Arun District Council
Arun Civic Centre
Maltravers Road
Littlehampton
West Sussex BN17 5LF
Planning & Building Control General Enquiries
Tel: (01903) 737756 Fax: (01903) 730442
Dx: 57406 Littlehampton
Minicom: 01903 732765
e-mail: planning@arun.gov.uk
website: www.arun.gov.uk/planning

Application No: A/193/20/PL
Site Address: Ham Manor Cottage Ham Manor Way Angmering BN16 4JQ
Description of works: Erection of a 1 No. 3 bedroom chalet bungalow & detached garage. This site is in CiL Zone 3 and is CIL Liable as dwelling.

Thank you for your internet representation made on 15th February 2021 which has been recorded as an objection with the comments as follows:

Proposed Street Scene (Scale 1:200)

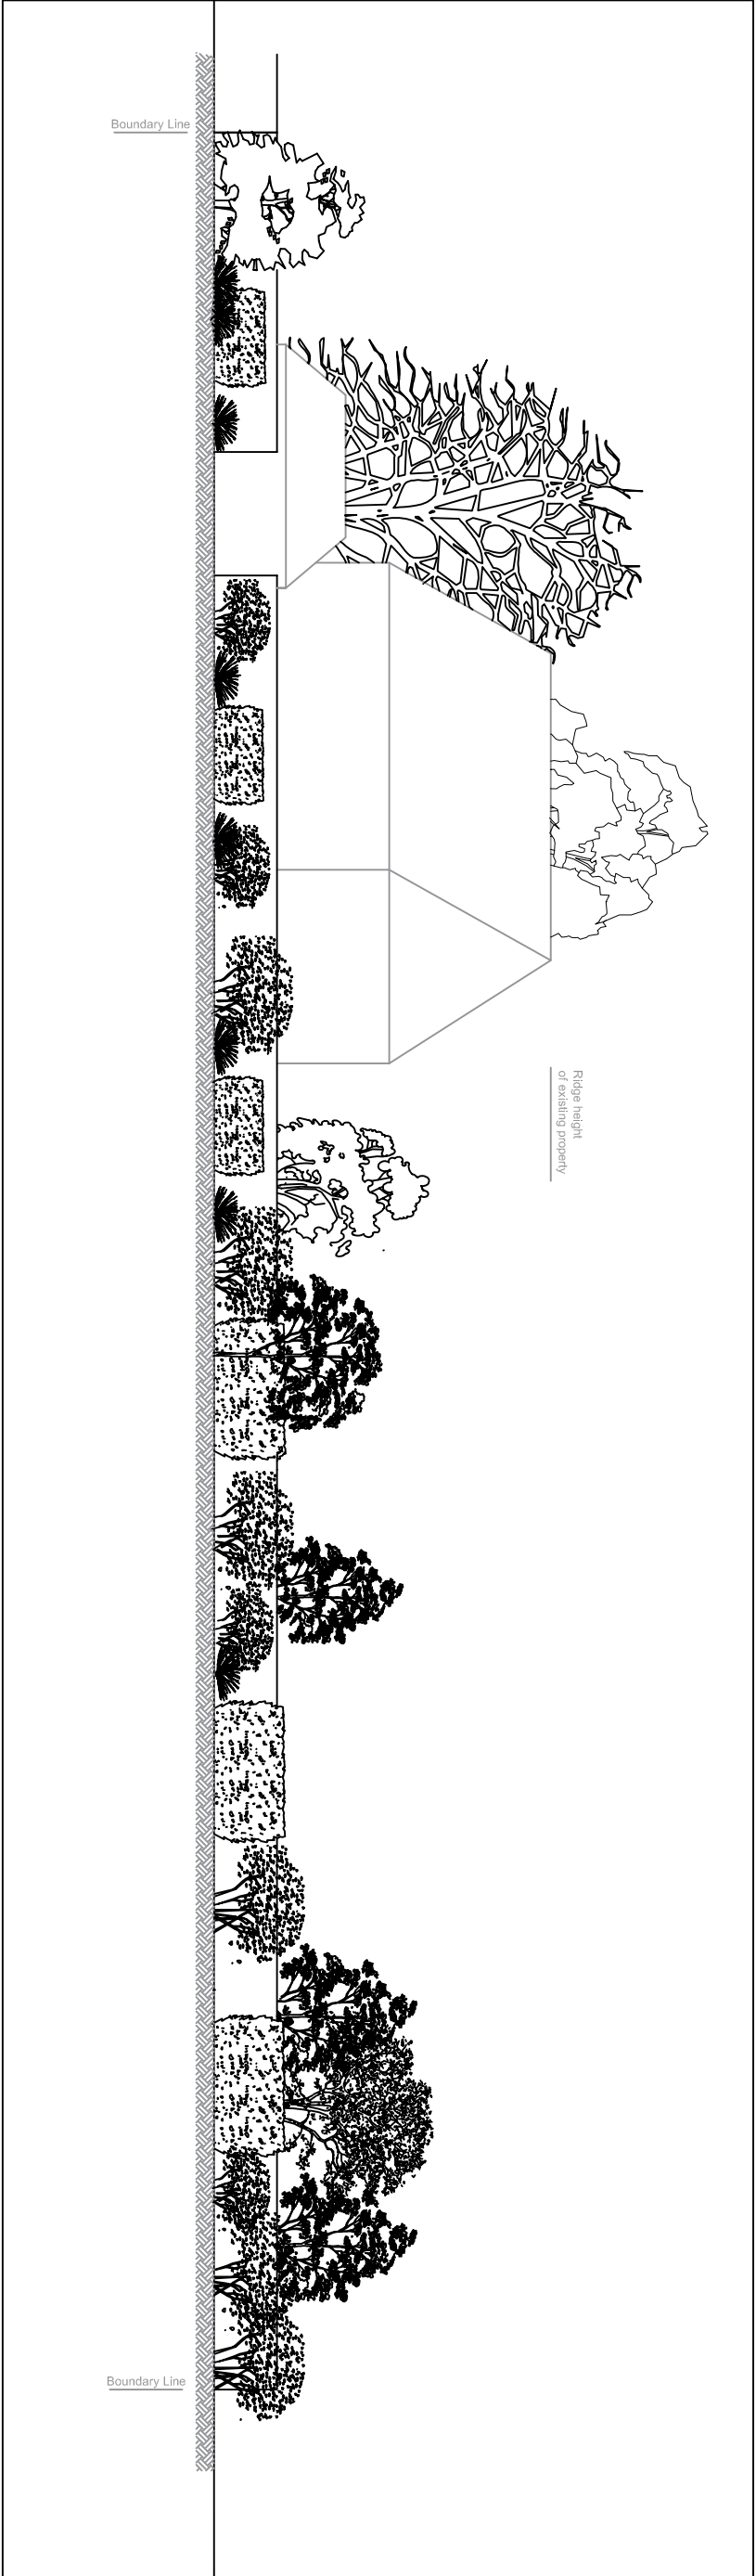
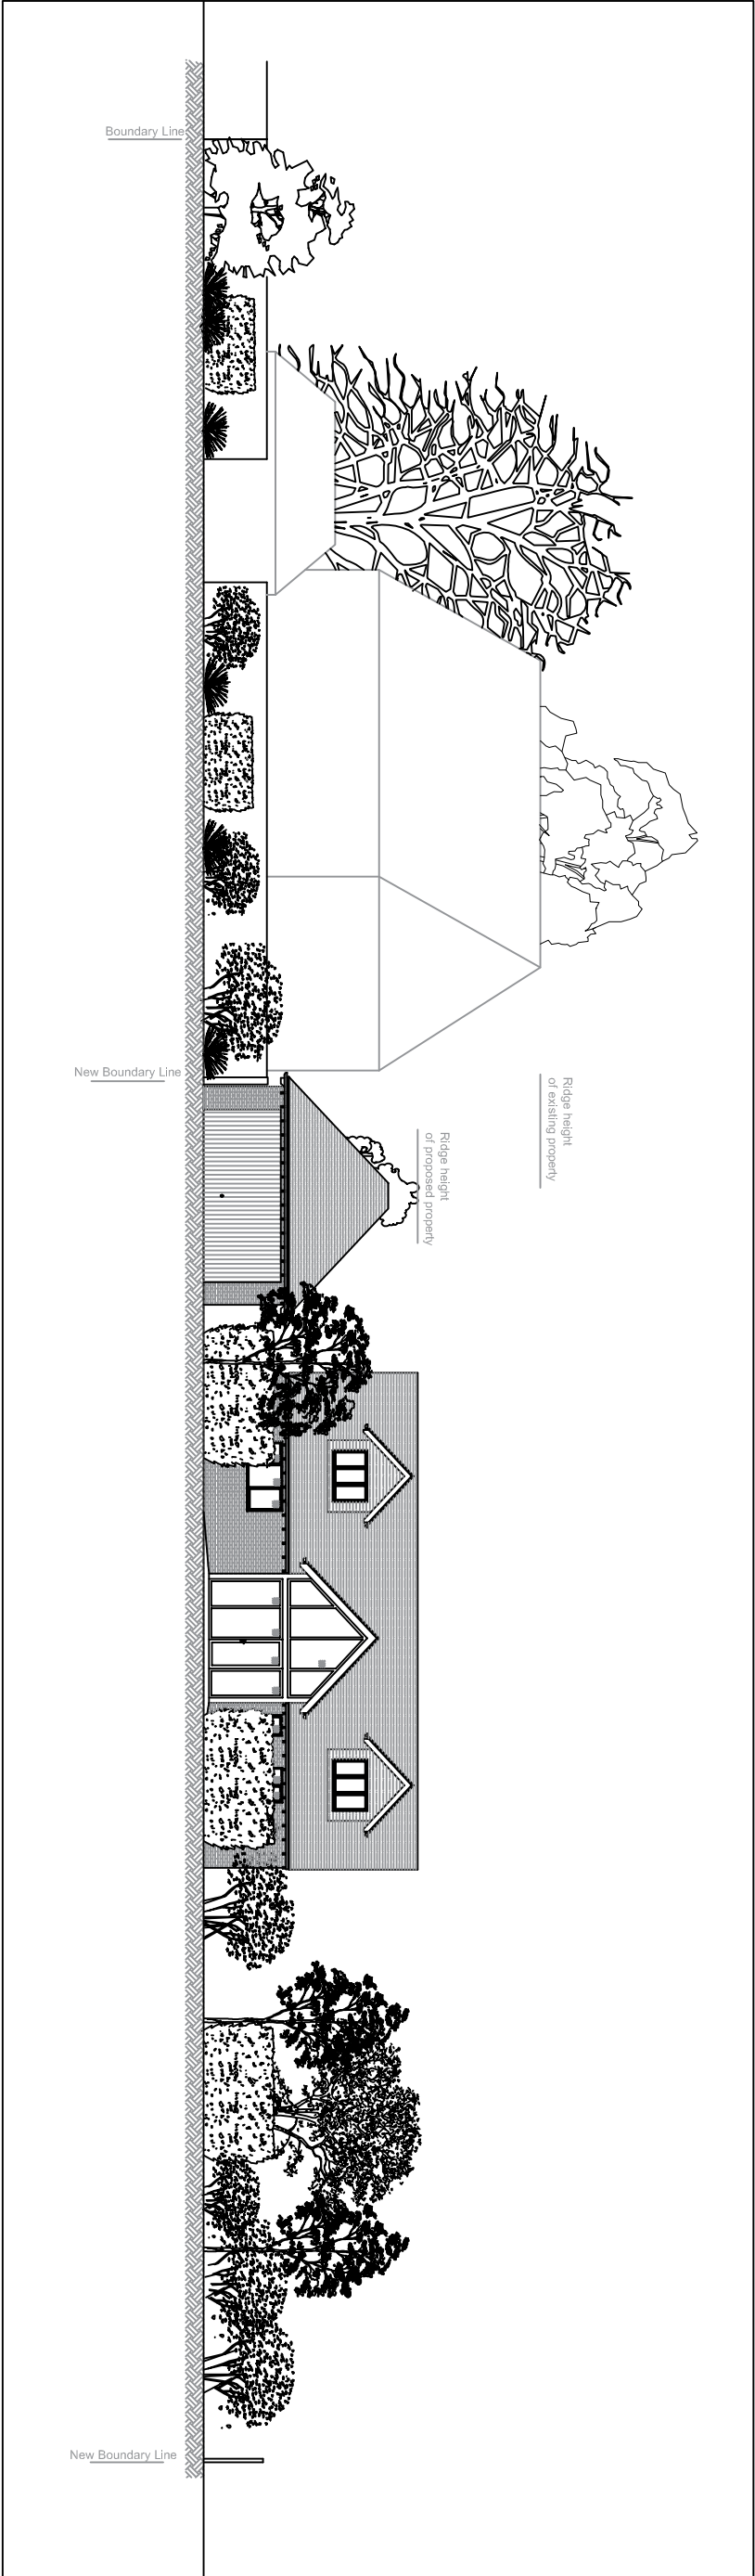
The proposed development is inappropriate within the street scene and is placed beyond the established build line as the site is too small.

the property doesn't relate to the surroundings, is cramped, not in line with other properties and is over the established build line (6.2,6.10,6.13,6.14, 6.16 and 7.2);
